## 3<sup>rd</sup> Update Report (June 2024)

This report has been prepared to assess the evidence provided for the discharge of Conditions 13, 20 and 36 of Outline Application 14/02121/OUT amended by 22/03492/NMA for Phase 2 of Himley Village. Additionally, this report assess updated information required to comply with S106 Schedule 11 (Zero Carbon) from 23/02786/OBL.

Figure 2 - Proposed EUI breakdown for the Himley Village development

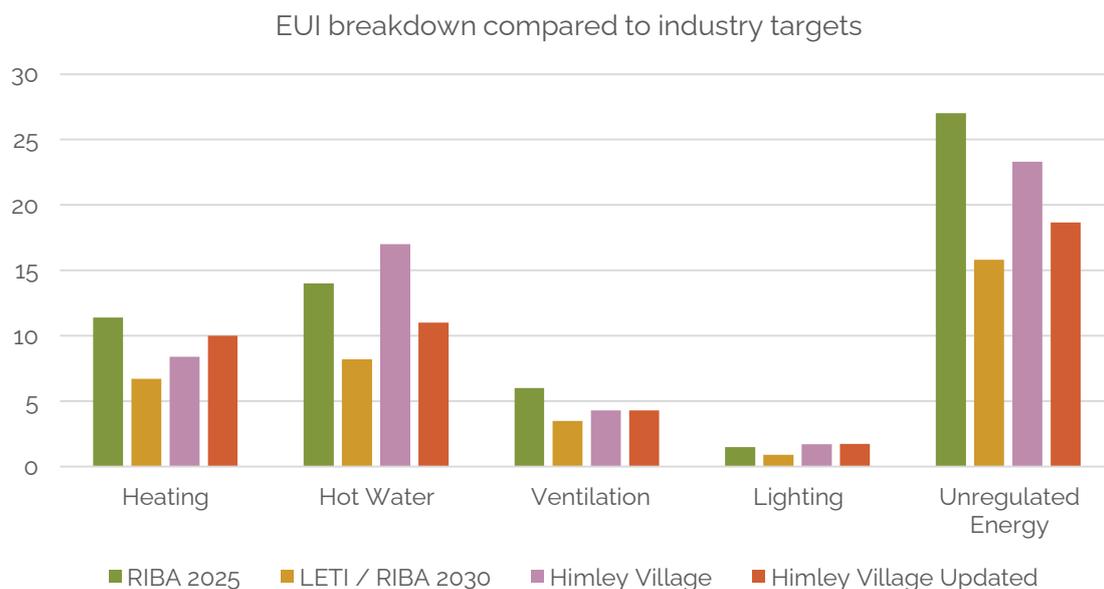
- Explanation of reduction in unregulated energy – any changes on occupancy profiles and improved equipment efficiencies – further detail required as below

The reduction from 23.3 kWh/m<sup>2</sup>/yr to 18.7 kWh/m<sup>2</sup>/yr was not explained in the Energy Strategy Addendum but has been explained in the May 2024 Energy Strategy. Reasoning for the reduction is attributed assuming 2 weeks of annual household absence for holidays, intermittency of fridge/freezer output and rationalisation of white goods. The first reduction attribute is acceptable in principle but the level of unregulated energy consumption reduction assumed from the three reduction measures is excessive and not sufficiently explained. Given that the EUI of the modelled dwellings is 45.7 kWh/m<sup>2</sup>/yr and the PV output of the phase is 46.9 kWh/m<sup>2</sup>/yr, it is essential that the reduction in unregulated energy is sufficiently justified since it is this reduction in energy consumption that has achieved the true on-site zero carbon definition – i.e. without the reduction to 18.7 kWh/m<sup>2</sup>/yr for unregulated energy, the true on-site zero carbon definition would not be achieved and the development would therefore be non-compliant with policy. Further detail is required on the remaining two measures to reduce predicted unregulated energy consumption and the individual contribution of each of the three measures towards achieving the 4.6 kWh/m<sup>2</sup>/yr reduction.

**In addition to the measures previously outline – we had rationalised the equipment as there was double counting in the number of screens related to the home office. Tumble dryers were also omitted as these will not be provided as part of the development.**

**Bioregional confirm this has been addressed. Additional commitment to ensuring unregulated energy assumptions will occur in practice has been issued.**
